Planning Act 2008 – Application by North Falls Offshore Wind Farm Limited for an Order Granting Development Consent for the North Falls Offshore Windfarm (EN010119)

I refer to the Rule 8 letter dated 4 February 2025 which sets out the Examination Timetable for the above Development Consent Order (DCO), currently at Examination. Essex County Council (ECC) in conjunction with Tendring District Council (TDC), and as described as The Councils, would like to provide a written response to the Applicant's submission at Deadline 4. Responses to ExQ2 are submitted separately.

# **Onshore Substation Zone of Theoretical Visibility and Viewpoint Locations with Dedham Vale National Landscape**

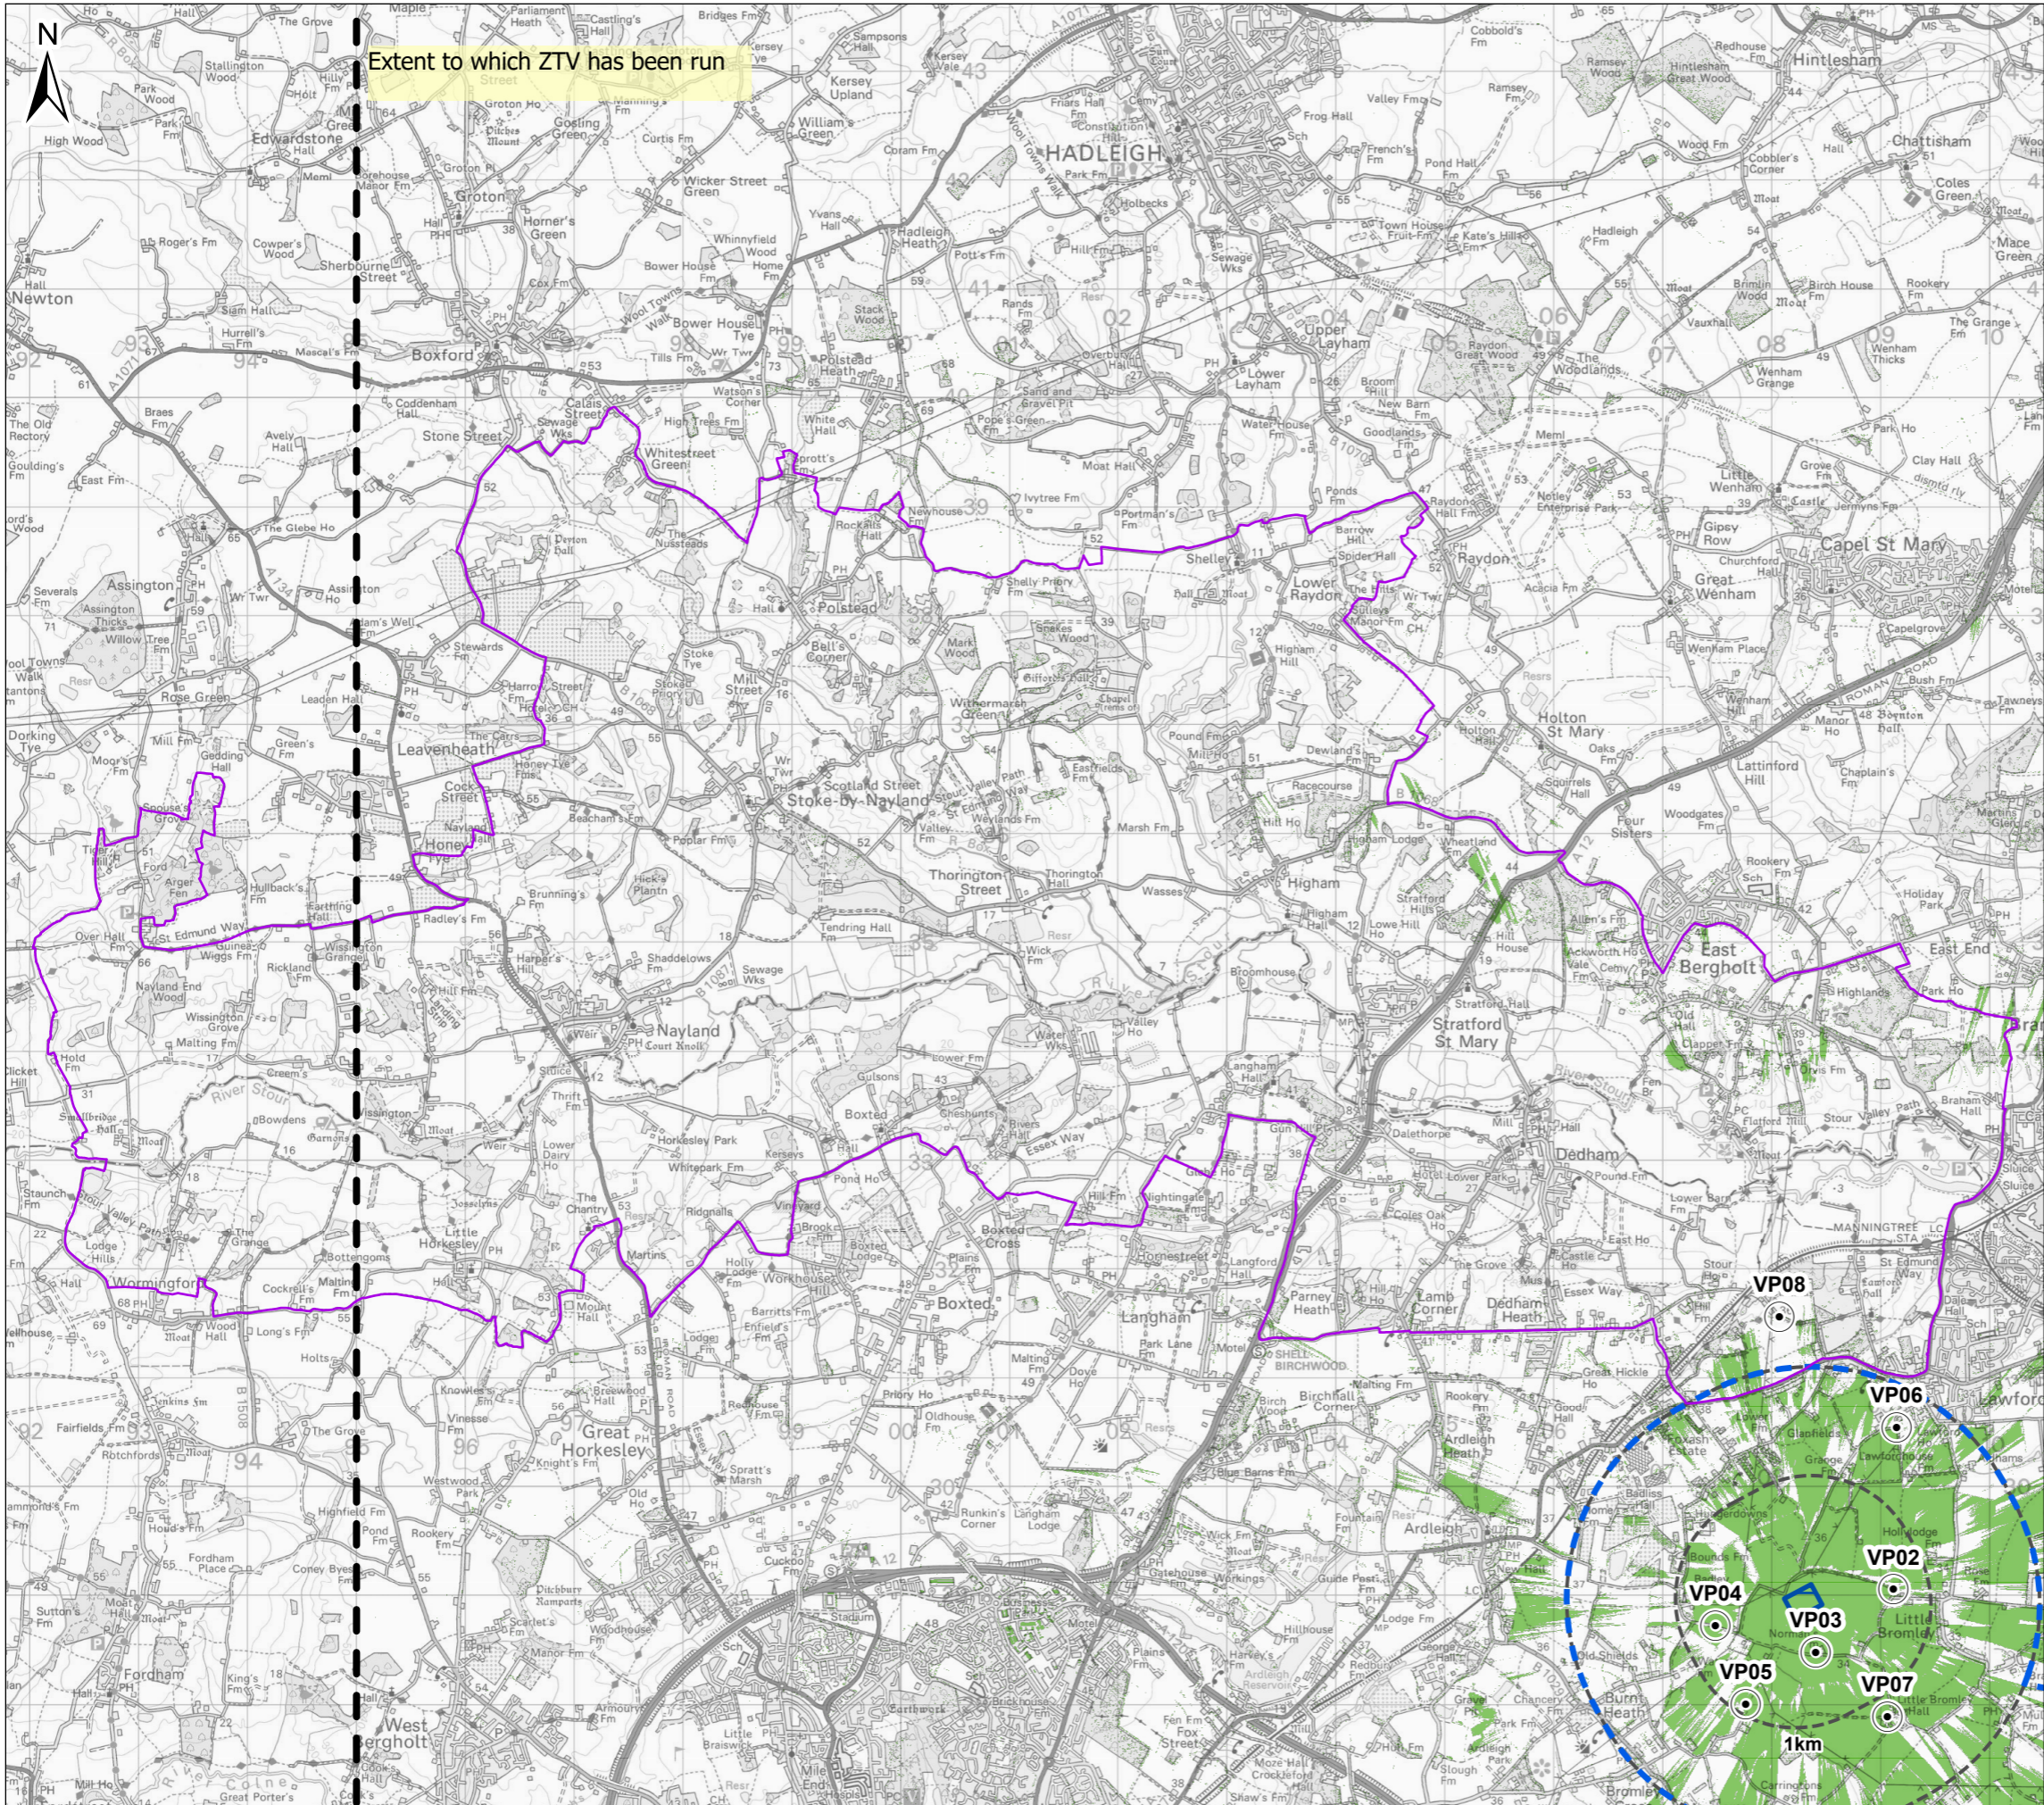
This demonstrates how the North Falls project by itself is potentially visible from additional points other than VP8 either within the National Landscape or within its setting. This visual impact will be enhanced in combination with Five Estuaries, the East Anglian Connection Node (EACN) and N2T.
